Application No: FP/70/21/PL
Site Address: Kenwood Court 6 The Midway Felpham PO22 7EZ
Description of works: Erection of a car port and rearrangement of existing parking spaces. This application is in CIL Zone 4 (Zero Rated) as other development.

Thank you for your internet representation made on 19th May 2021 which has been recorded as an objection with the comments as follows:

PROPOSED GROUND FLOOR PLAN
SC. 1:100

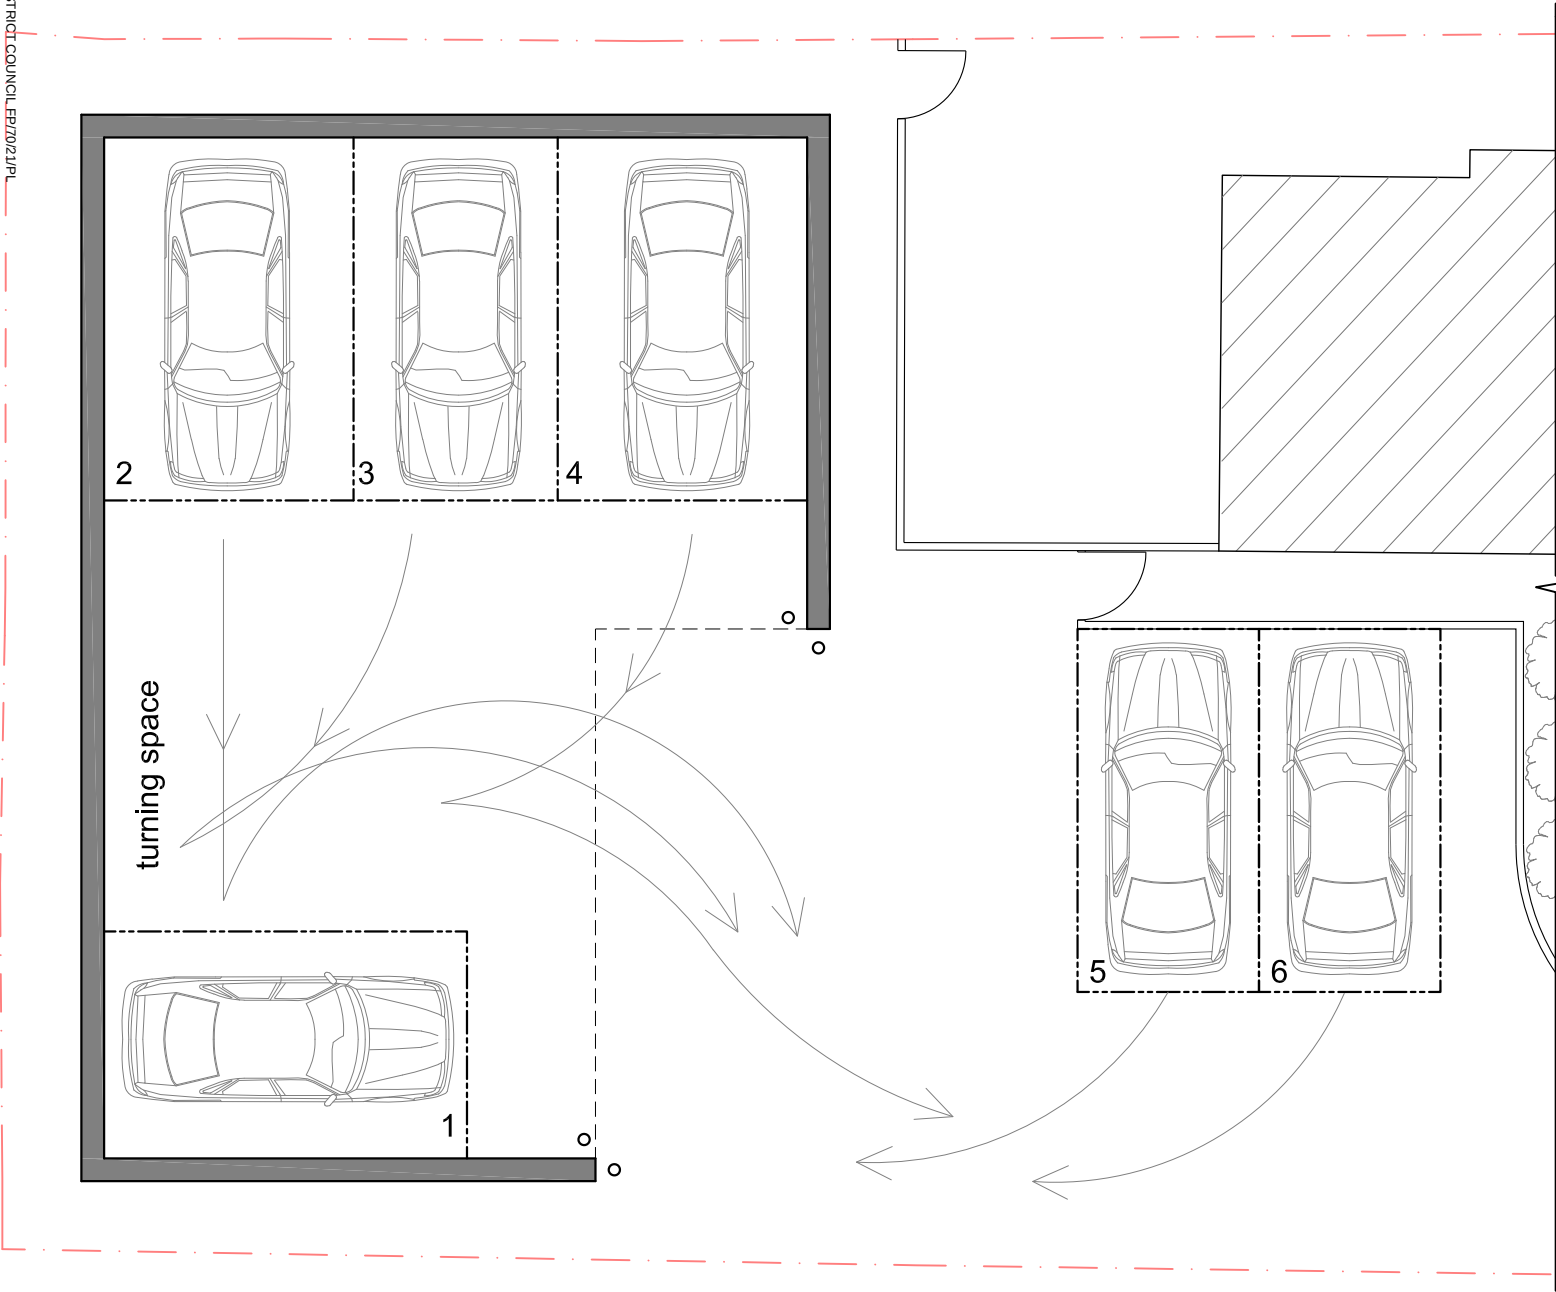
The two car spaces at the front of the property would be adjacent to our bedroom, so all car lights would shine straight into the bedroom
